155 Washington - demo and addition permits

Demolition Permit

Addition Permit

North & South Elevations
A.04

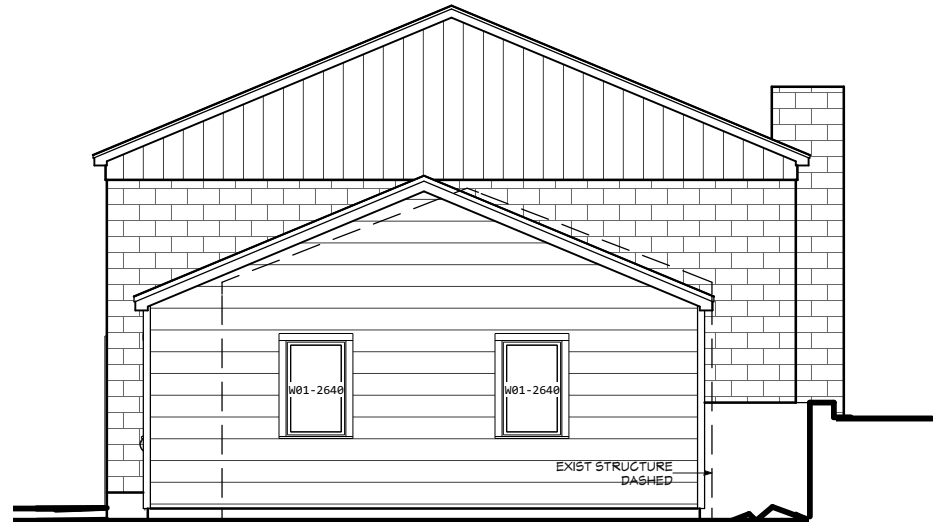
- (1) Please see the North and South Elevations (A.04) of the plans.

The old structure has a ridge height of 13'10" and the new structure has a proposed ridge height of 14'4" resulting in a 6" difference. I followed up with my architect, Kevin Moquin, and he explained that he wanted to match the roof pitches of the existing cinder block building (5/12 pitch) with the proposed addition for aesthetic purposes. He further explained to me that, within the 15' setback area (non-conforming portion), the new building is actually shorter than the existing shed because of the proposed pitch. The new ridge line, which is 6" higher than the old one, lies beyond the 15' set back and conforms with the height restrictions of the zone.

If this line of argument doesn't suffice, I can talk with my architect about either lowering the wall height or decreasing the pitch of the proposed structure to bring it down 6". Please let me know what the City will require.
